June 24th 2015

Application M/56/15/HH: 31 Sea Way, Middleton-On-Sea, West Sussex, PO22 7RZ

I wish to enter my objection to the above proposed development on the following grounds:

Proposed Elevations  
Sections B-B  
C-C  
D-D

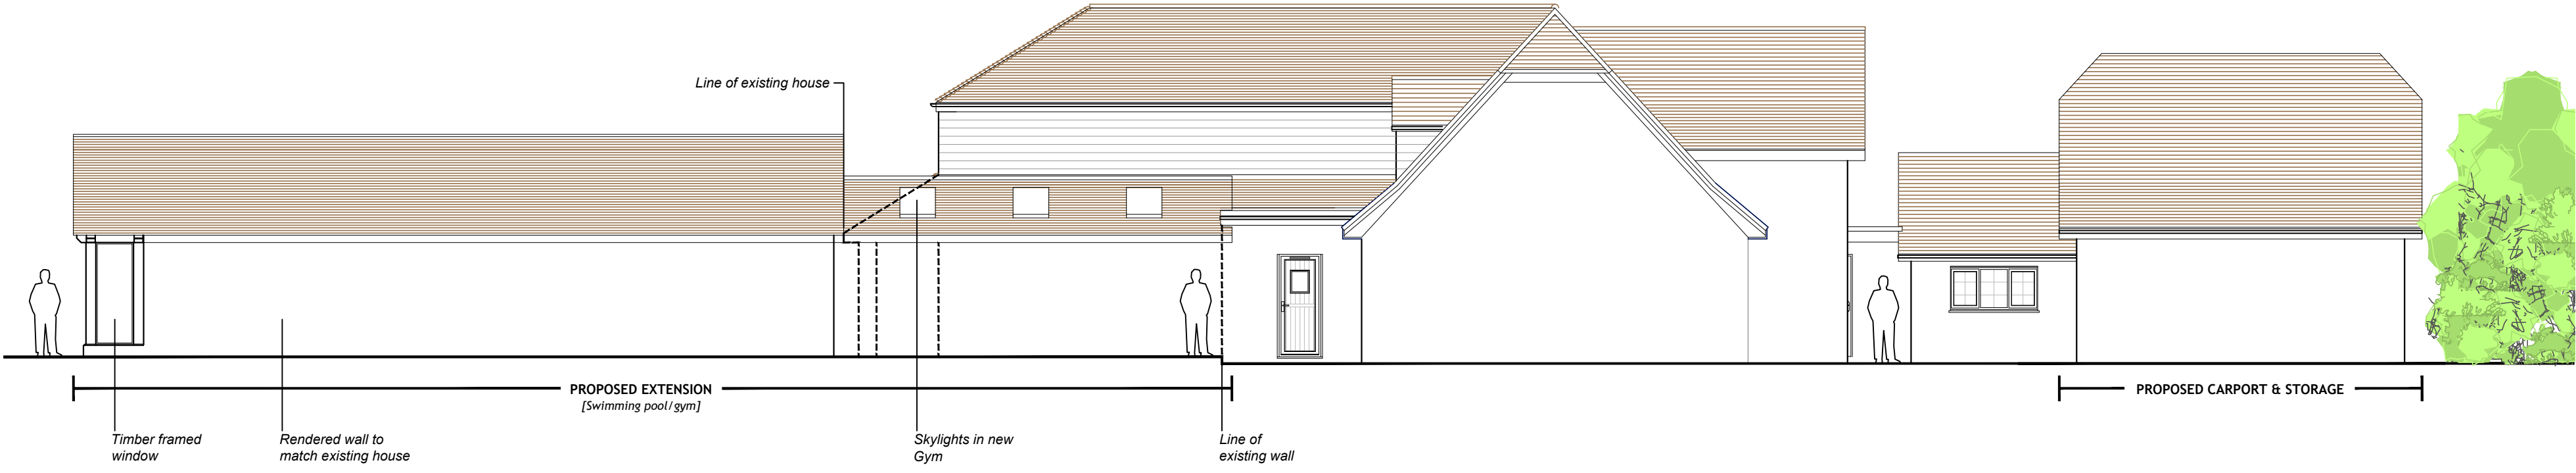
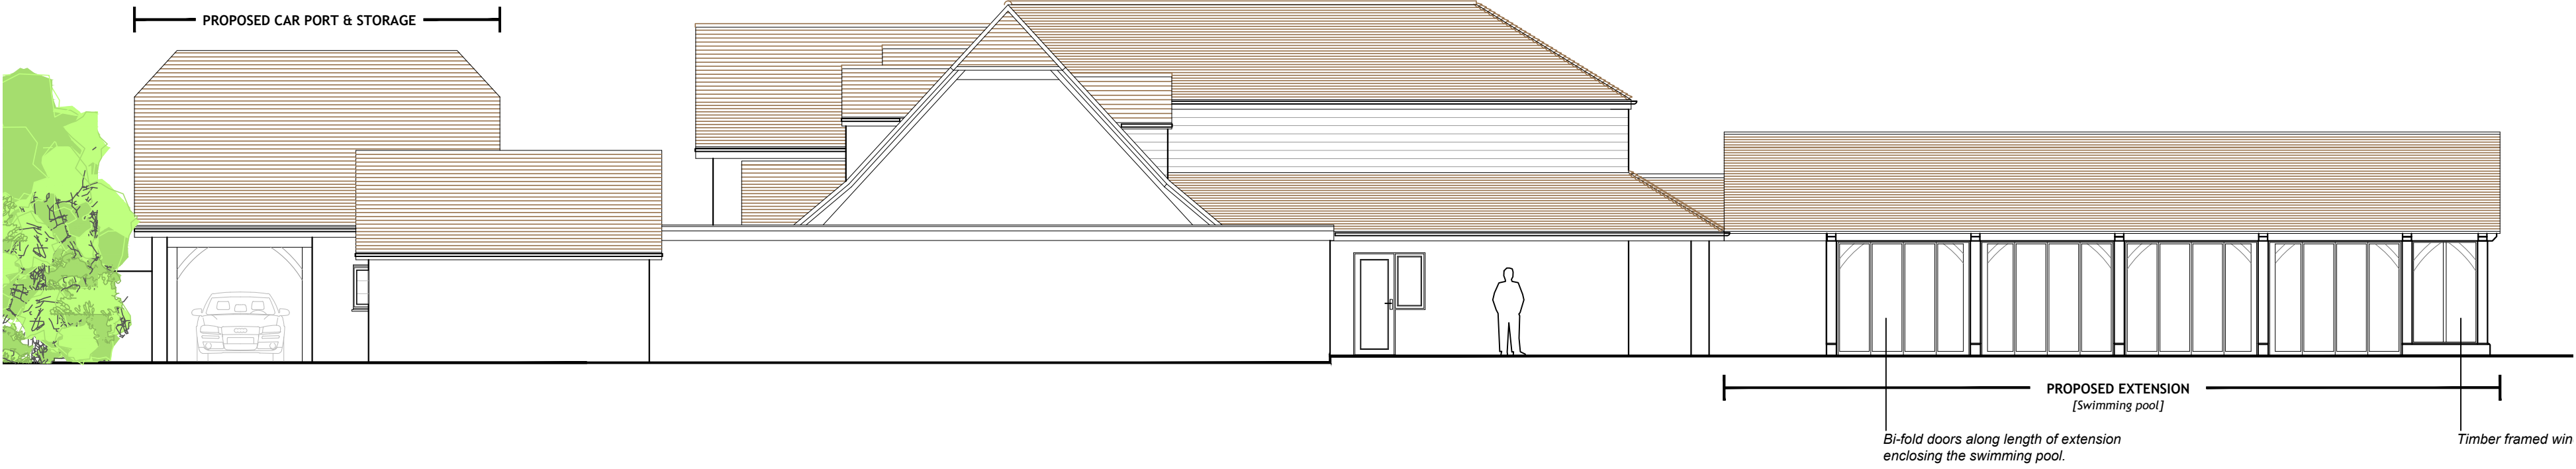
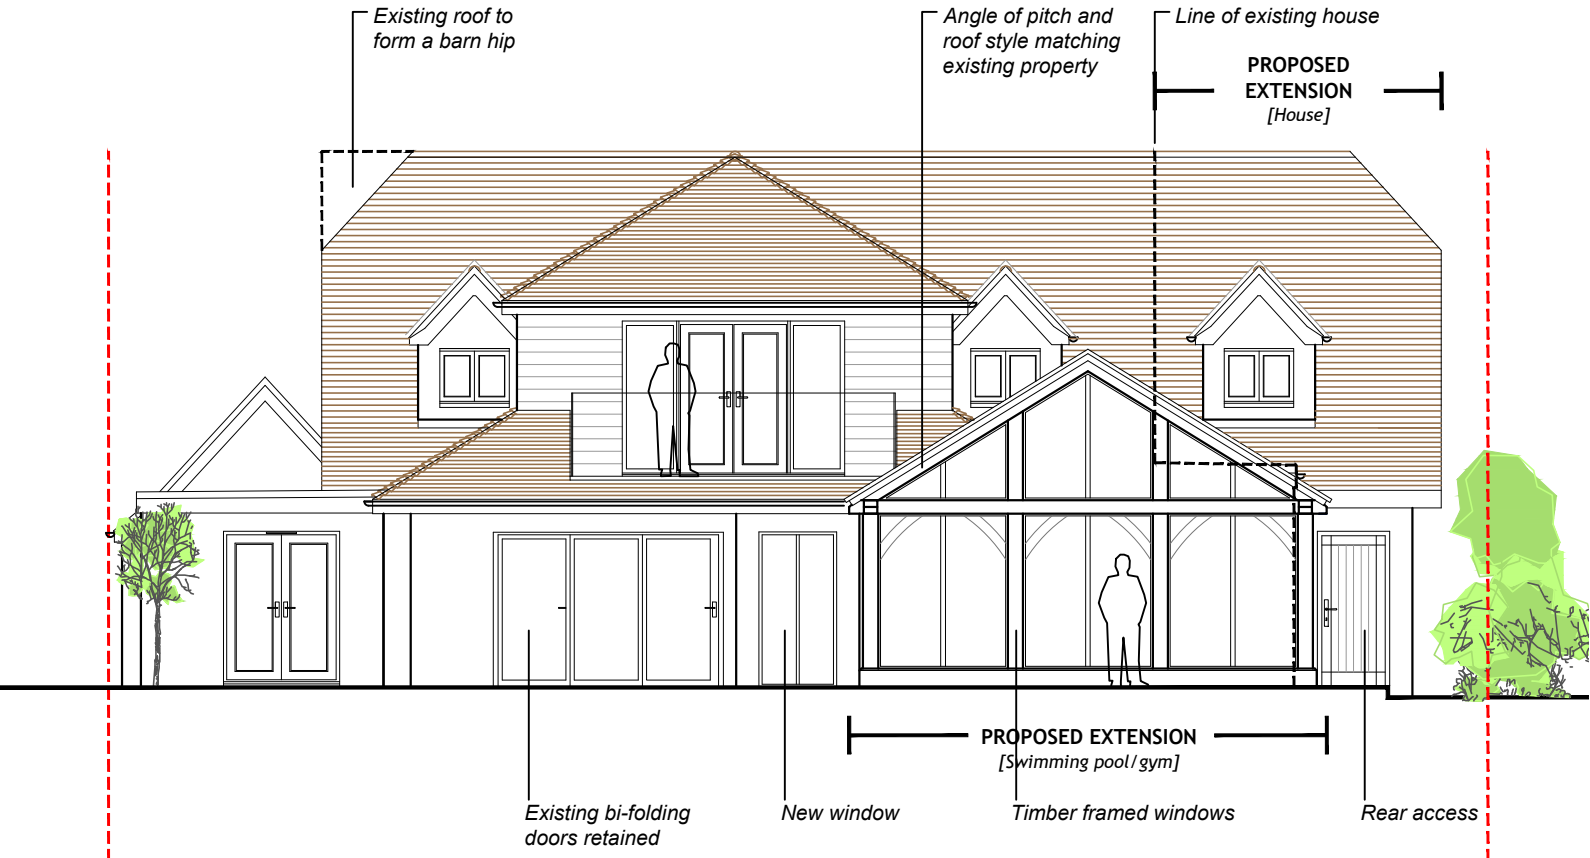
4. The bulk of the 'blind' wall and high pitched roof of the proposed garage building so close to the boundary line at both the east and north. The long bulk of the building will seem quite dominating – even if the current hedging or new planting or indeed a wall were in place. Again the precedent of building so close to the boundary of a property close fronting the road is of major concern. I am unsure why the building needs to be so high if it is not intended to use the roof space for 'accommodation' of some sort in the future

Surface Water Drain
Sea Way
Middleton-on-Sea

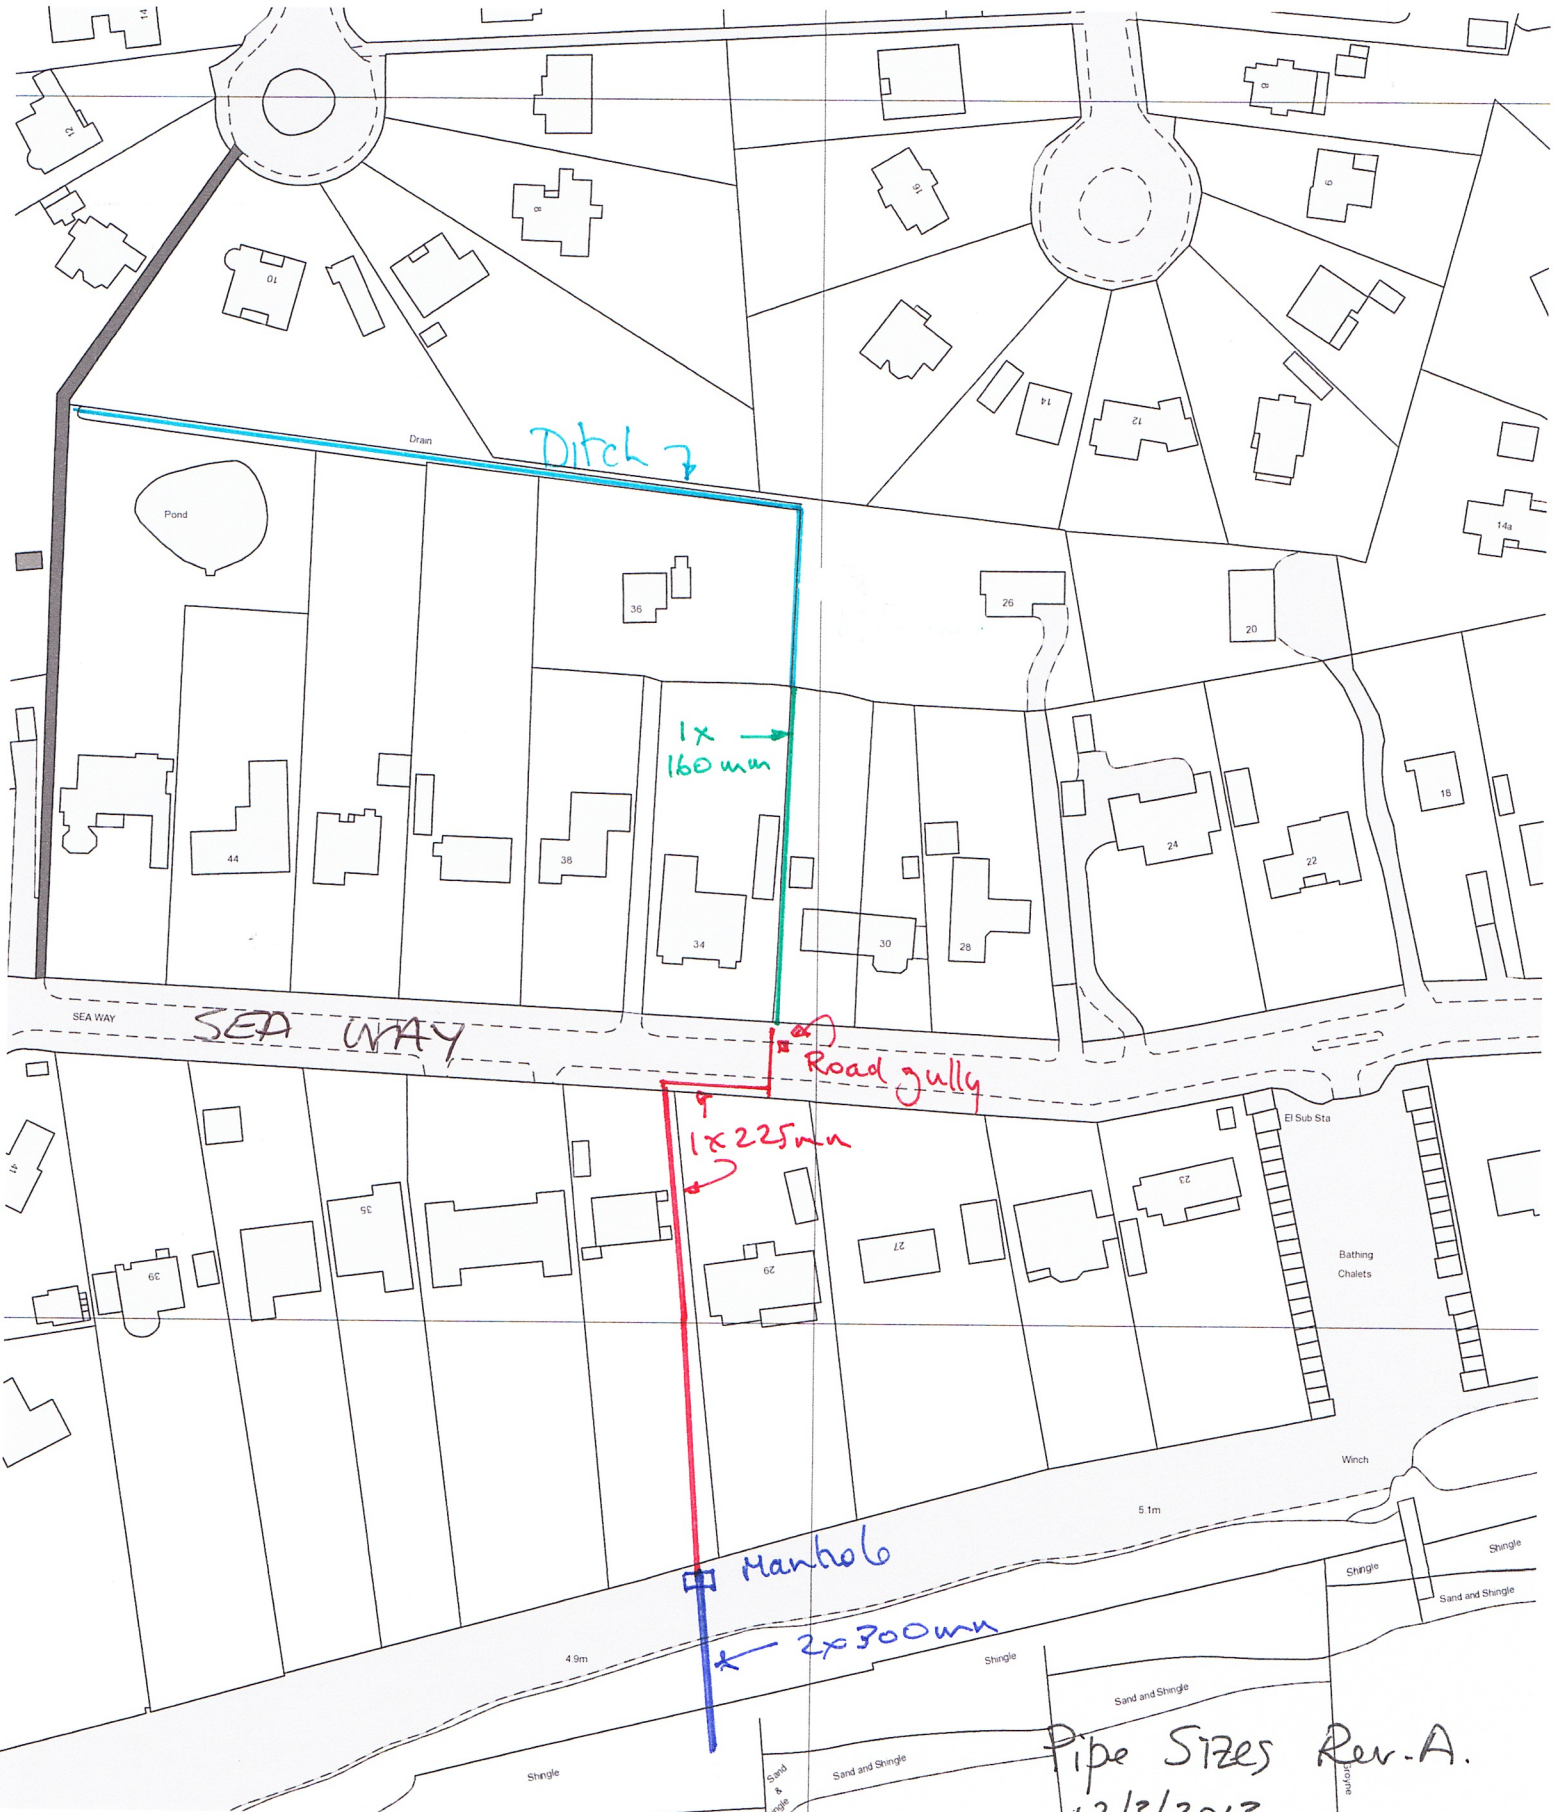
6. The possible damage to the recently re-instated and costly land drain that runs across Sea Way Road and takes a route (rain water that drains down from West Close/East Close) directly through 'The Little House' property to egress under The Greensward and shingle and out to sea. I appreciate that this may not be seen as a planning matter but I would want to have this item noted for further consideration and a specific note attached with regard to any future planning as the weight or disturbance of the proposed building work – in particular in this case the load bearing weight of the proposed garage and high pitched roof in the front of the property as well as the support structure for the proposed pool enclosure could materially affect the ability of the drain to work effectively.
